DOC20/900559-13

EPA Advice on Submissions Report

Thank you for the request for advice from Public Authority Consultation (PAE-10590984), requesting the review by the NSW Environment Protection Authority (EPA) of the Submissions Report for the proposed New Berrima Brickworks Facility (Application SSD-10422) at 416 and 524 Berrima Road, Moss Vale.

Figure C.2: Incremental 24-hour average maximum HF concentrations ($\mu\text{g}/\text{m}^3$) (General land-use assessment criteria: $2.9 \mu\text{g}/\text{m}^3$ – red contour)

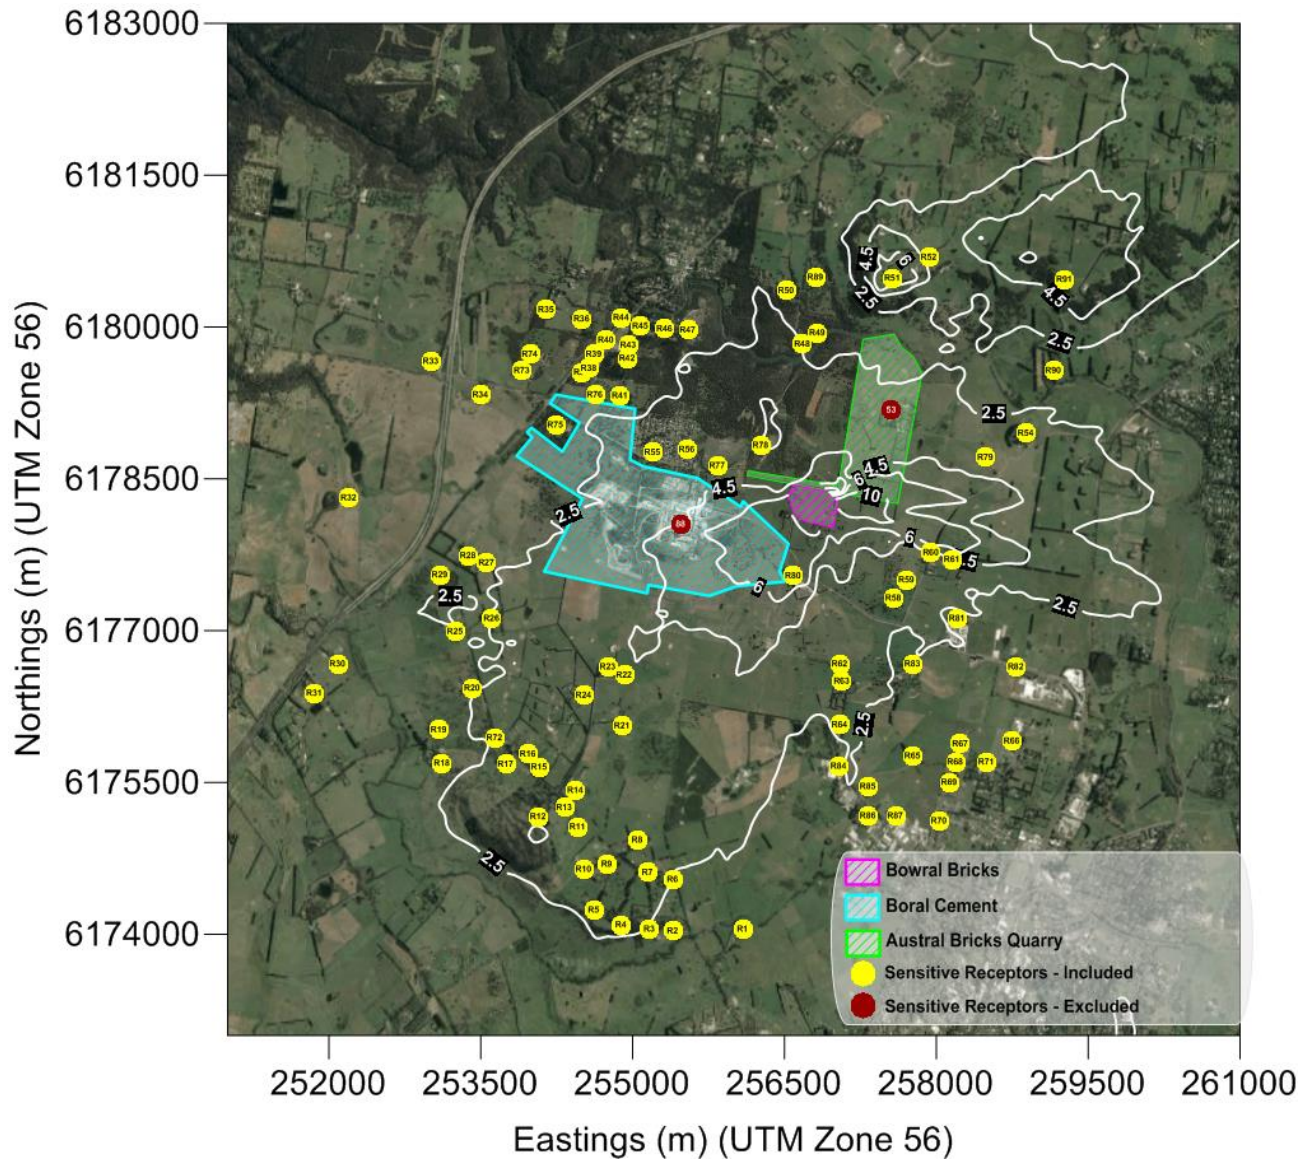
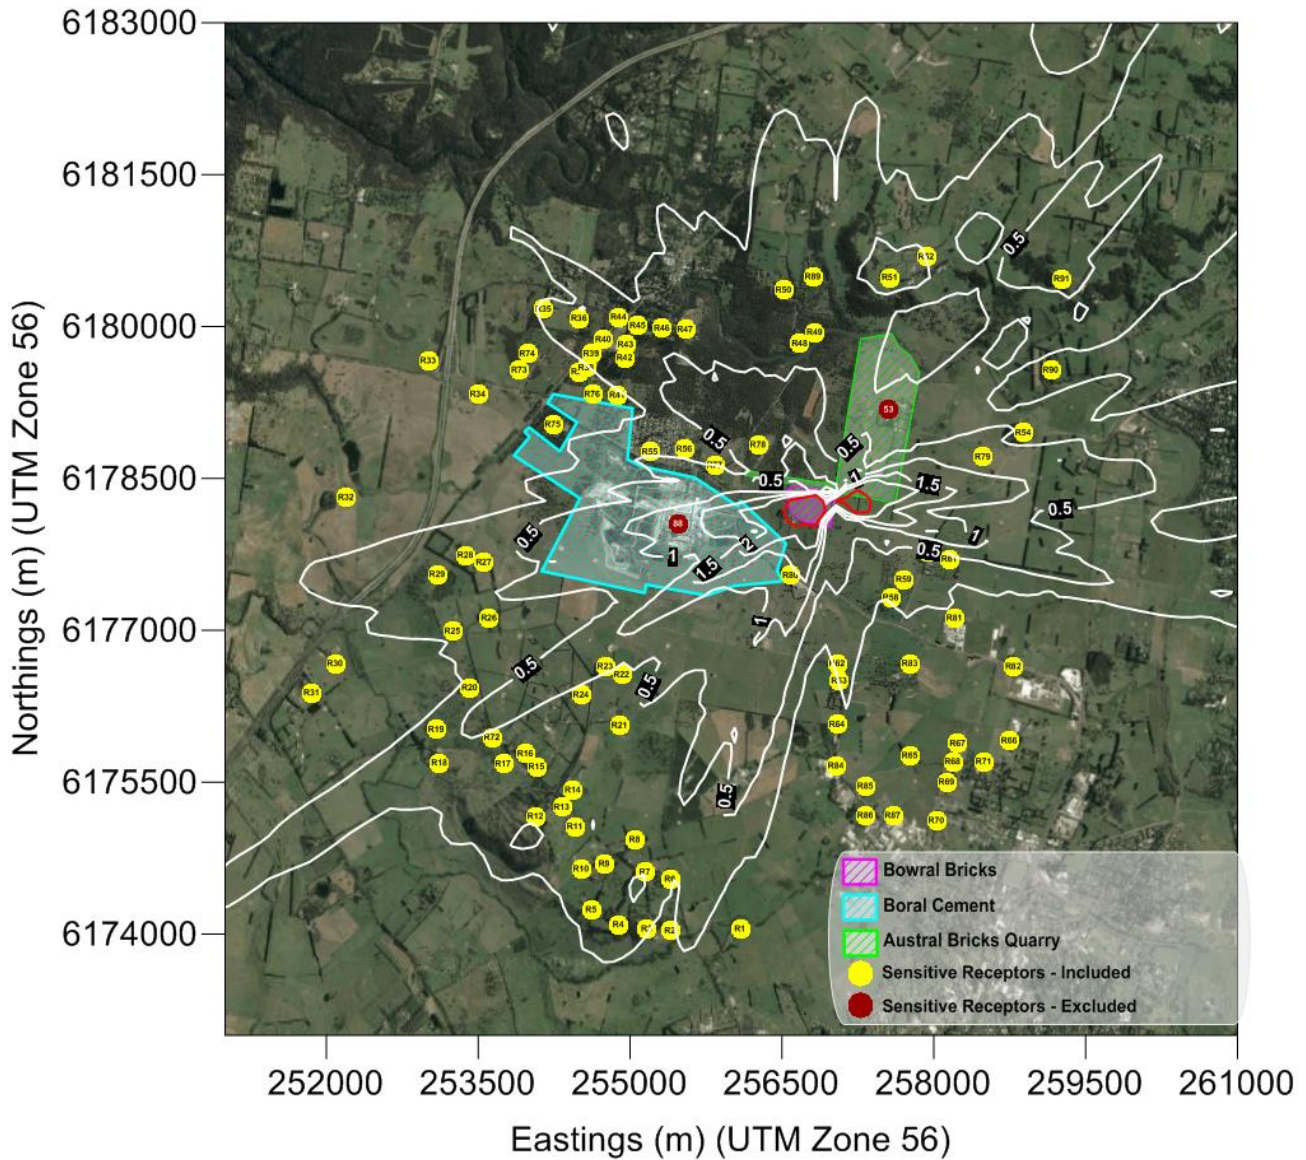
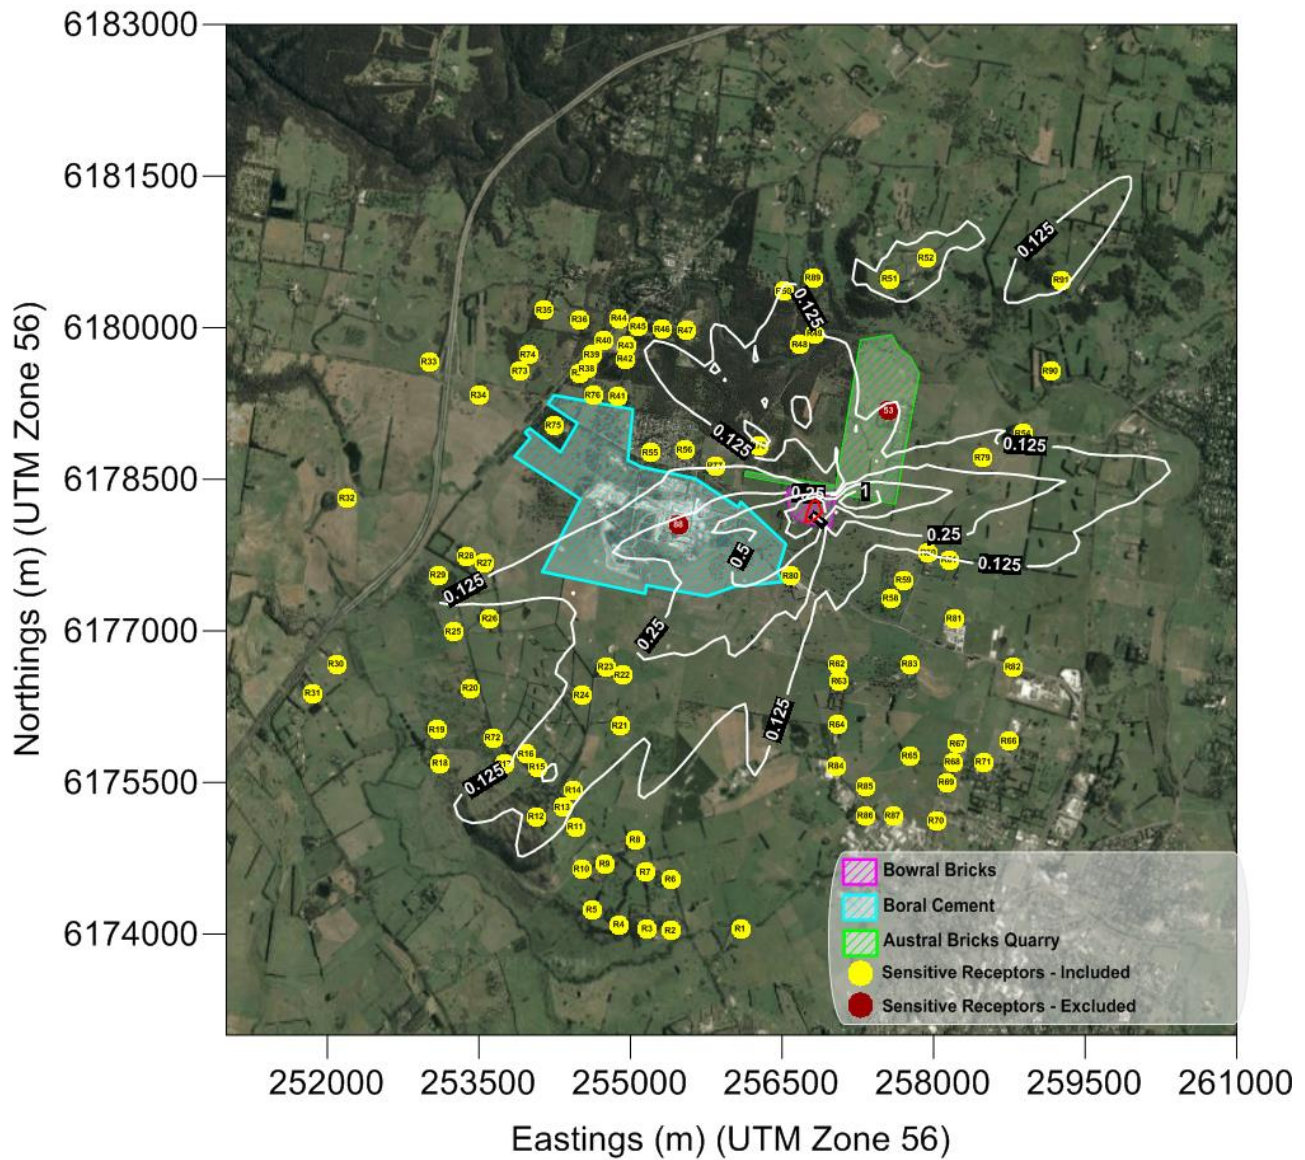
Incremental and cumulative HF ground level concentration isopleths have been overlaid on the Wingecarribee Local Environmental Plan 2010 to determine the extent of the predicted HF impacts. When the sensitive land use assessment criterion of $1.5 \mu\text{g}/\text{m}^3$ (24-hour) is applied, the results of the dispersion modelling show predicted impacts above the EPA's impact assessment criteria in the land zoned E3 to the North West of the proposed facility. As such, there is potential that future specialised land use potential in this area may be affected, including vegetation sensitive to fluoride, such as grape vines and stone fruits.

The EPA recommends the proponent be required to provide supporting evidence of the information considered in Airlabs survey of the potential for sensitive lands surrounding the proposed project site.
